Planning and Urban Development Department Planning Division

Subject: R-5 Design Review – 84 Irving Street

Date of Review: Friday, September 16, 2016

NORTH FACE ELEVATION  
84 IRVING ST. PORTLAND ME  
1/4 SCALE

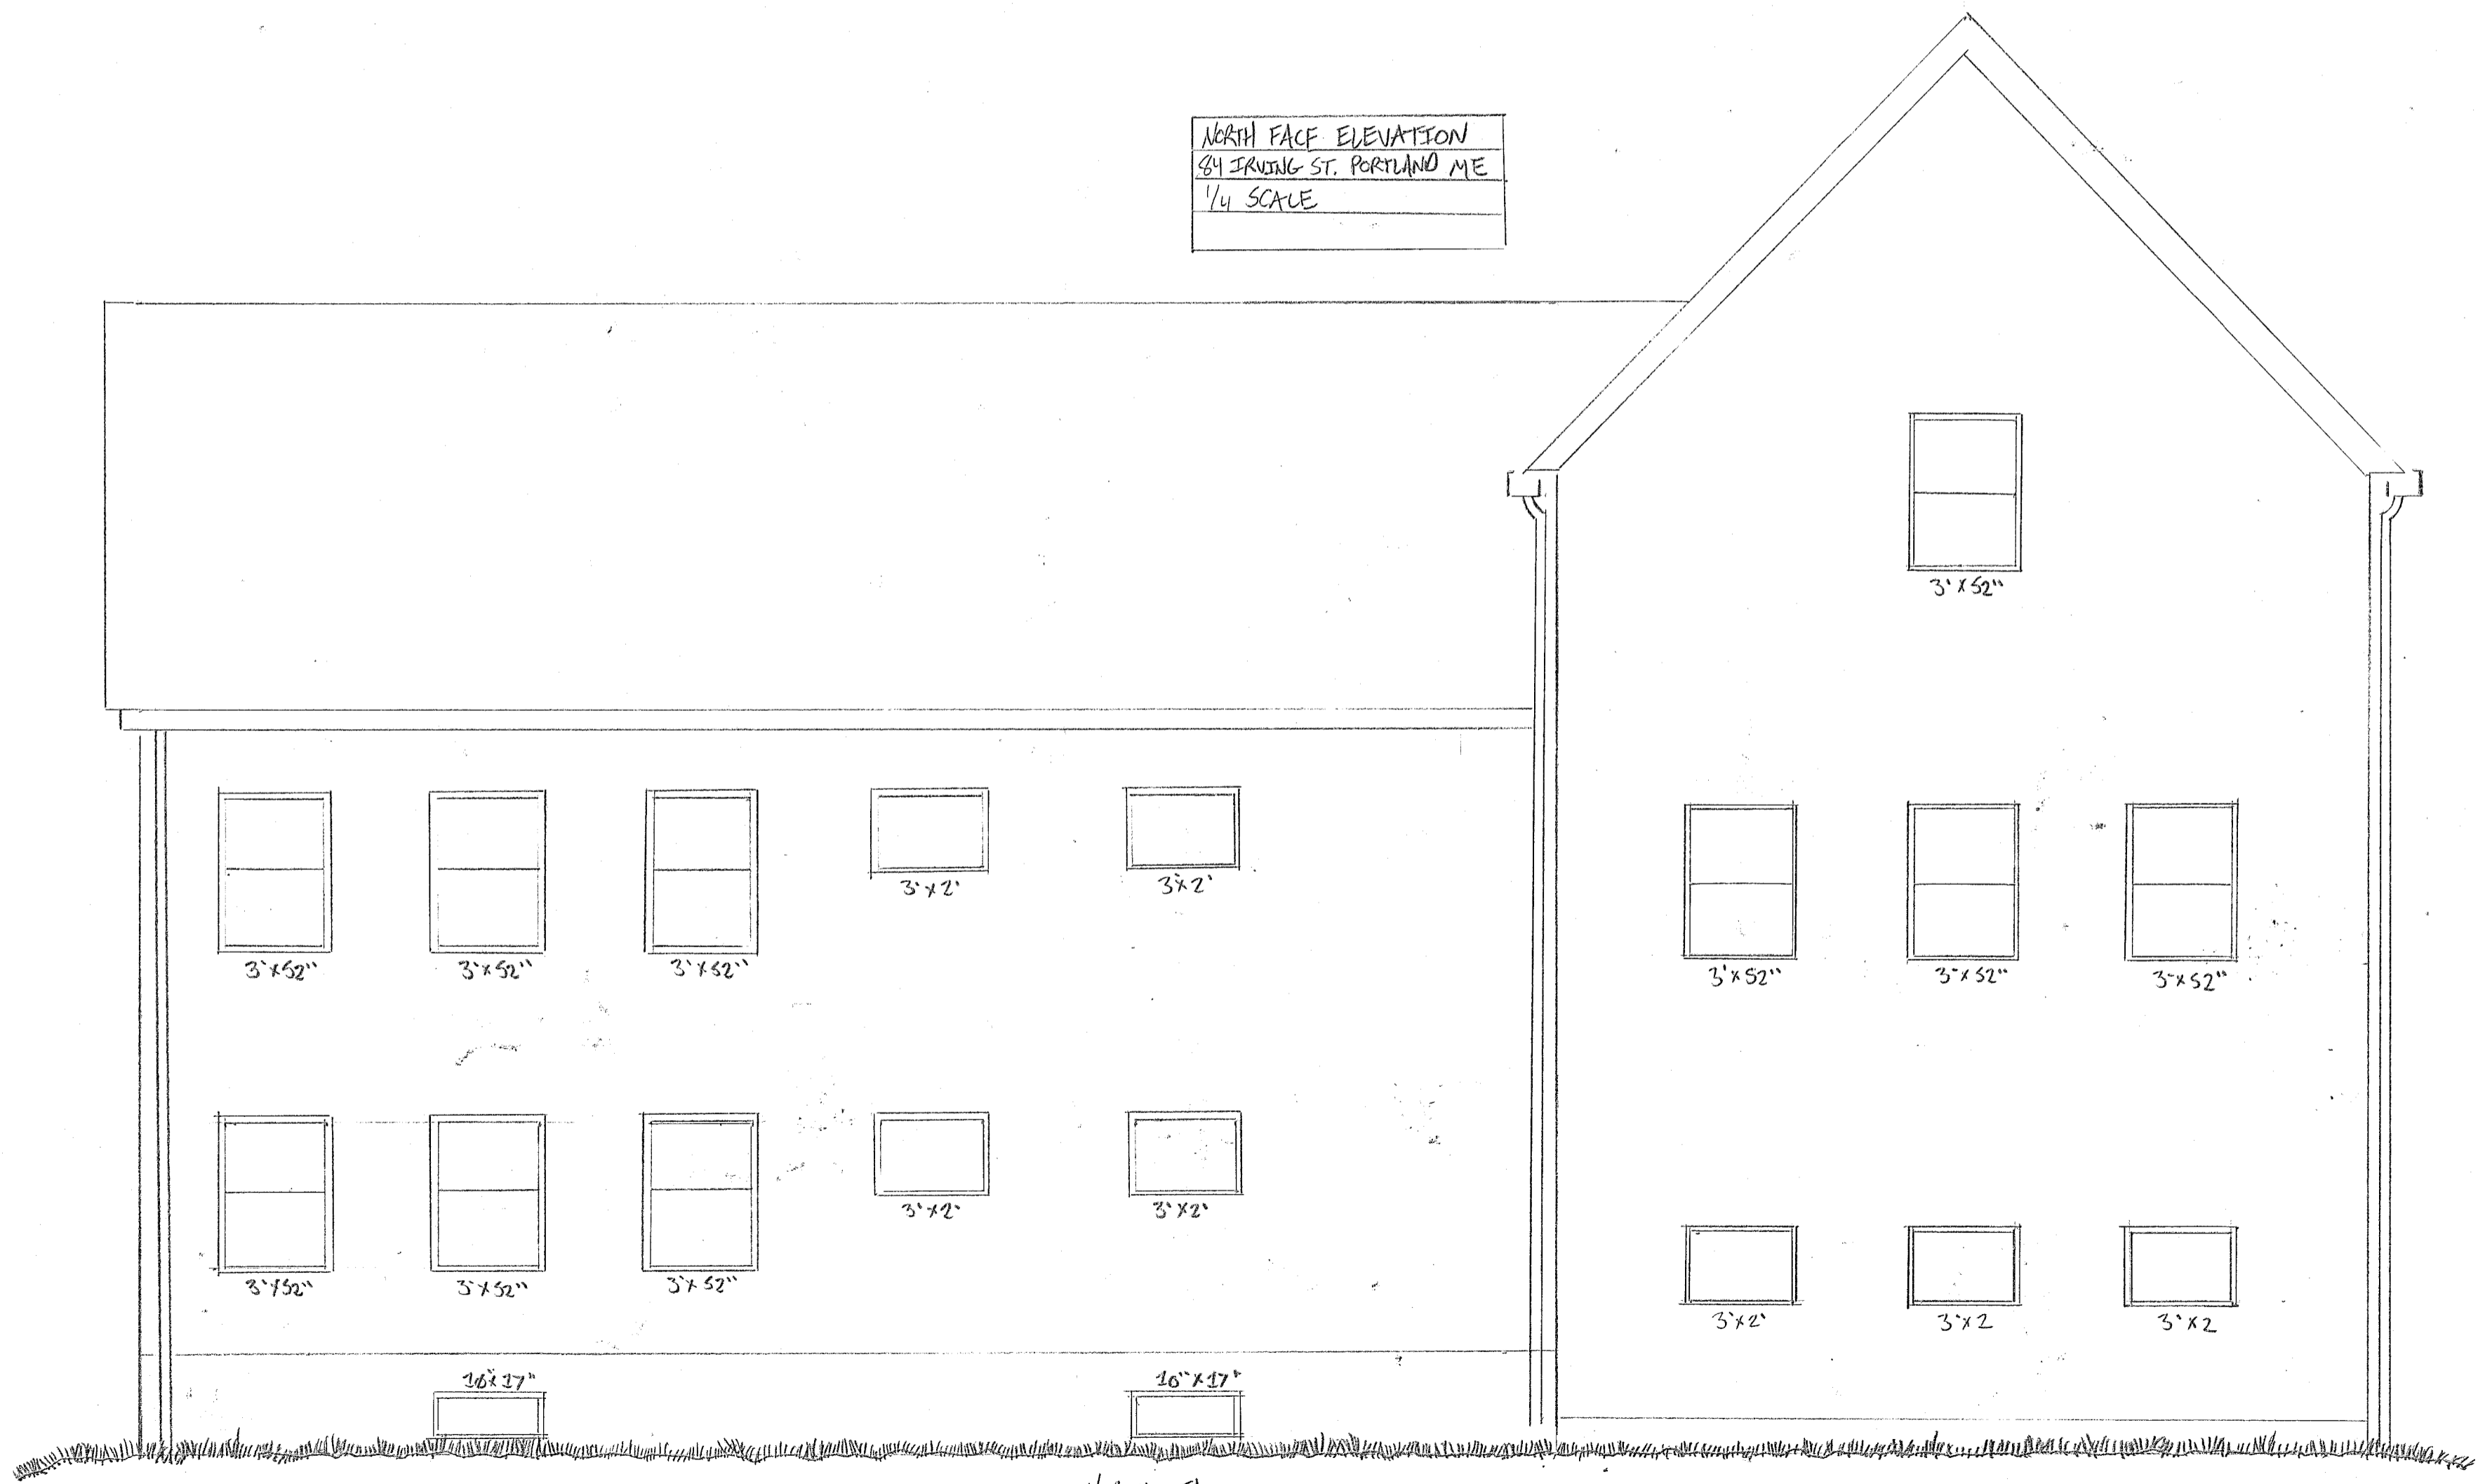
- The principal façade and entrance are side-facing – the street façade is being treated like a side façade.
- **The standard requires a side-facing entry to include a porch or covered entry that extends towards the street.**

- **Street façade is lacking articulation. Street facades in this context include an entry with porch, stoop, or canopy and/or window bays. At least one of these elements or a similar architectural feature is needed.**
- **At least 15% of street façade needs to be fenestrated.**
- **The windows have a vertical proportion but are shorter, it appears, than the context. Make sure the window height/proportion are comparable to street.**

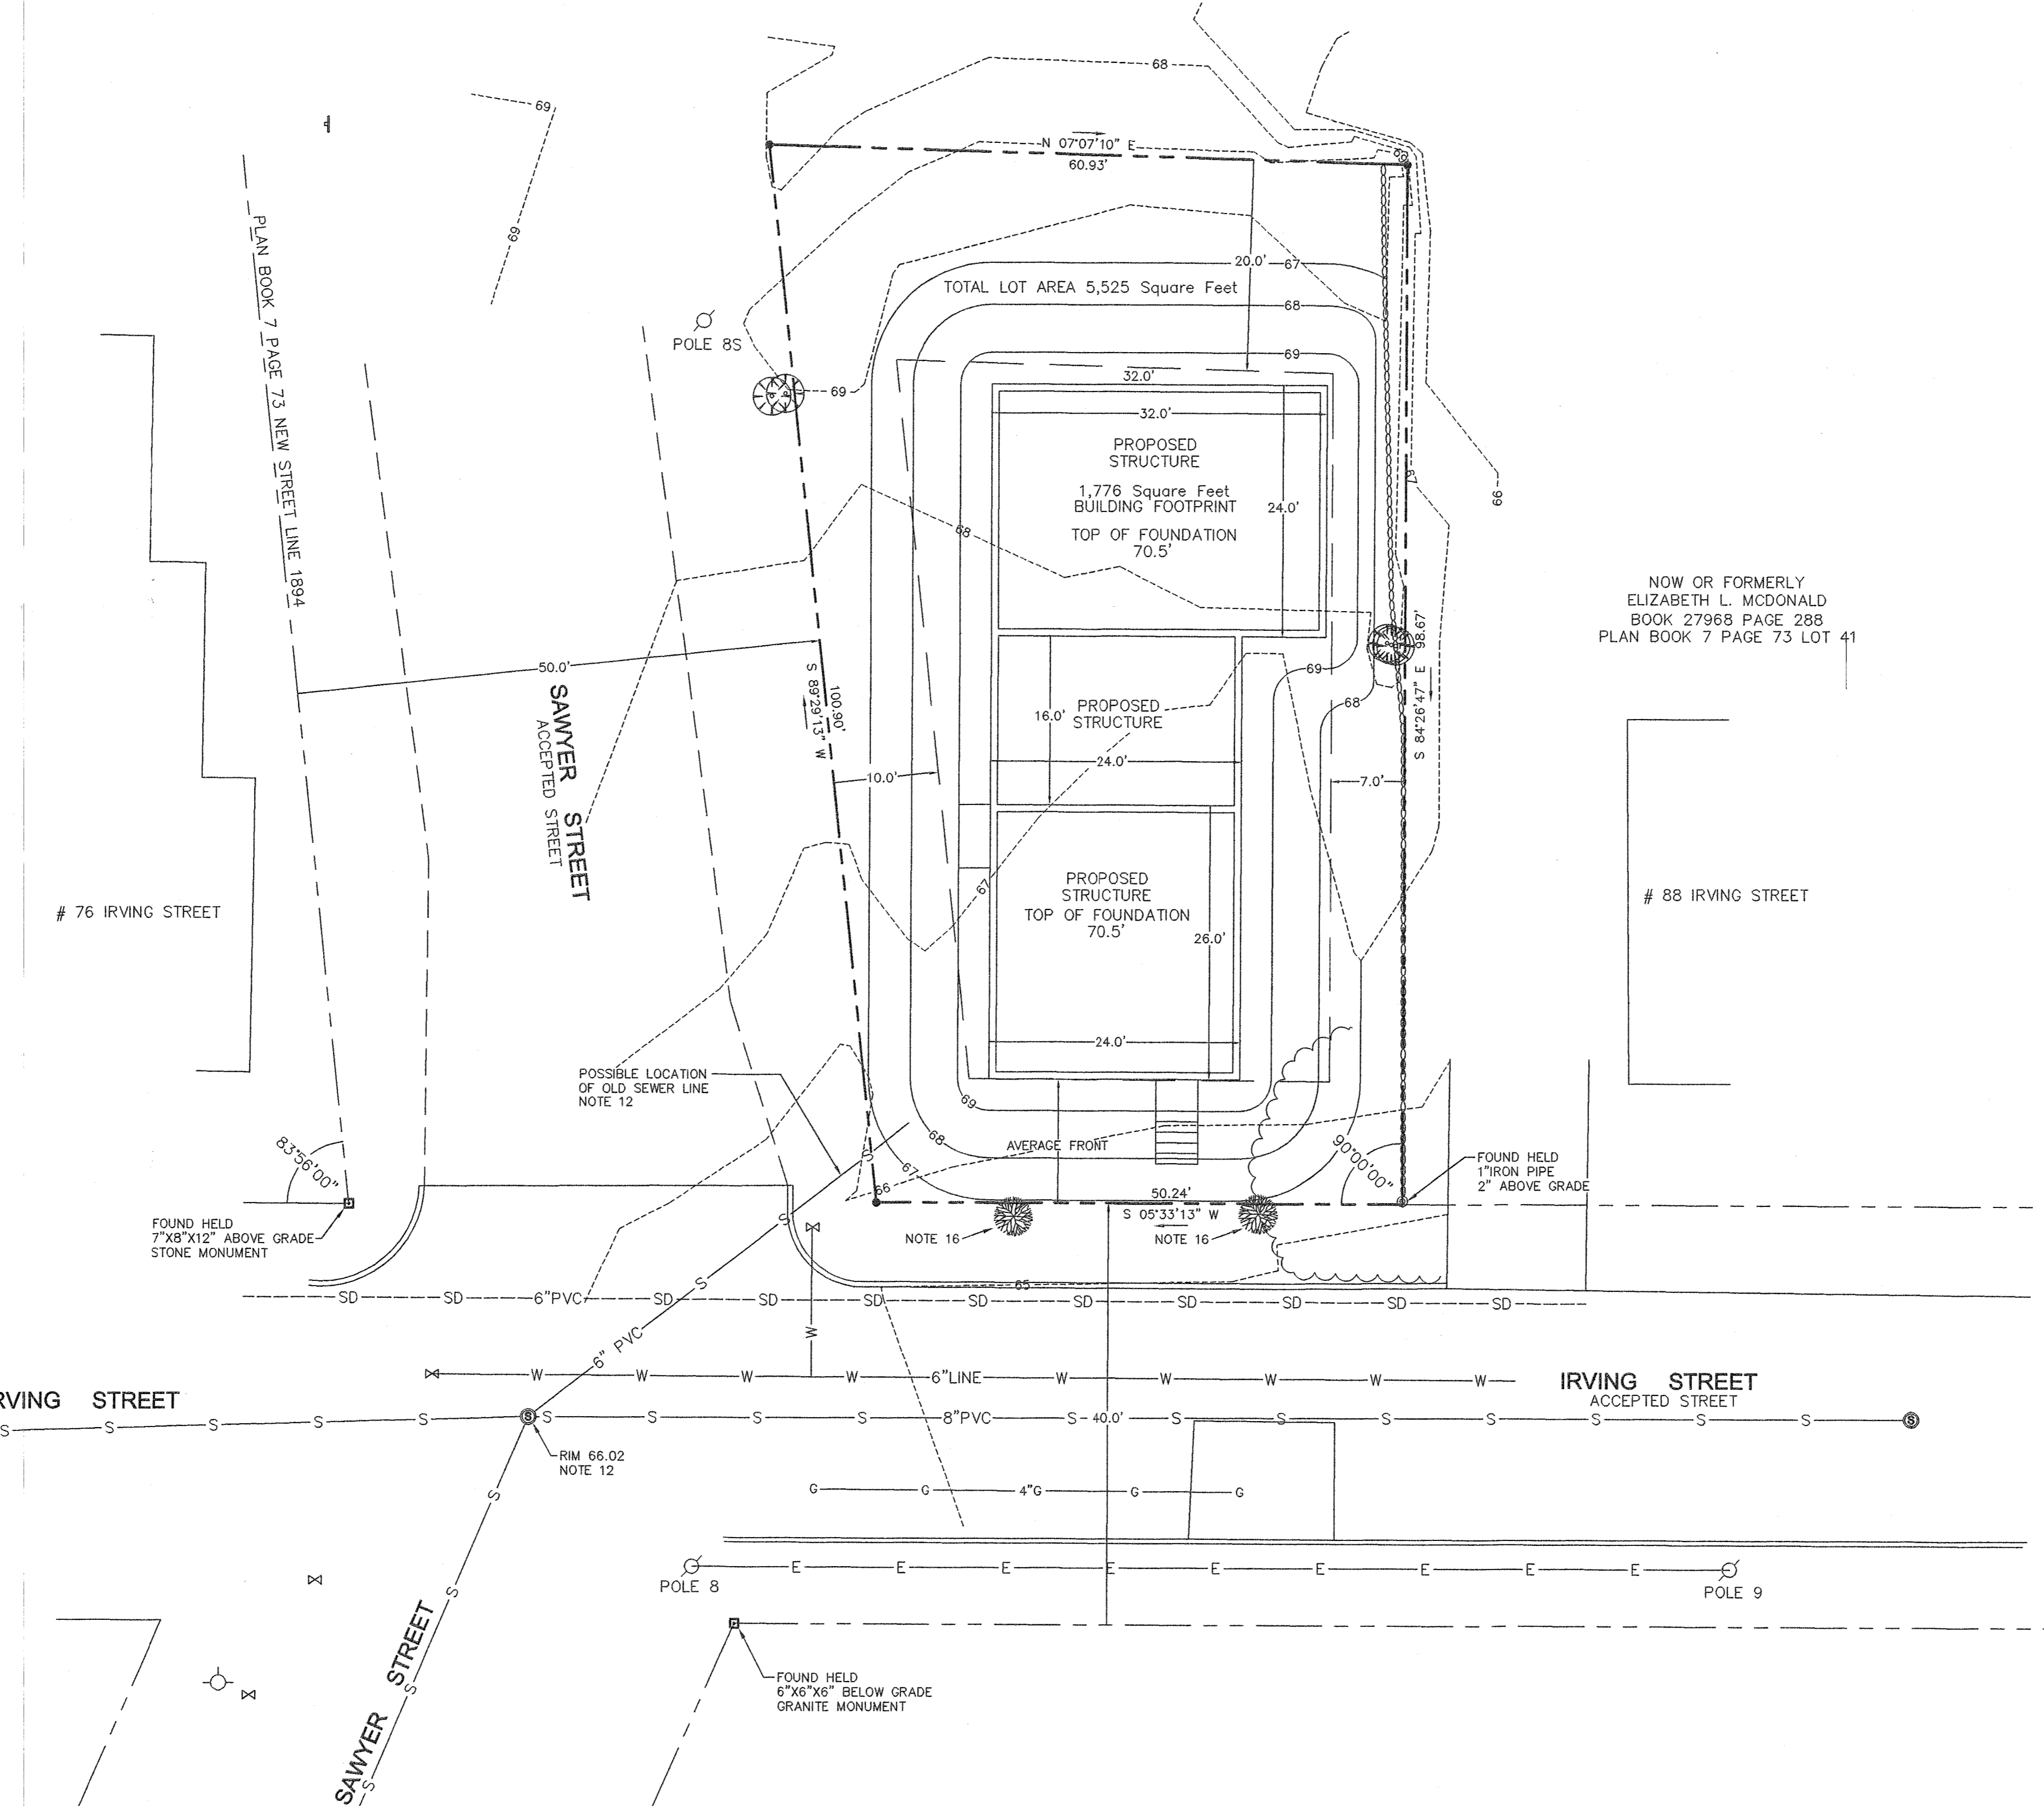
- The main entry to the building is side-facing – provide a paved path to the entry from the sidewalk.
- It appears building will be set back from street to a comparable degree with neighboring buildings but not clear without a site plan. Building should be set back enough to provide privacy for ground-floor spaces.
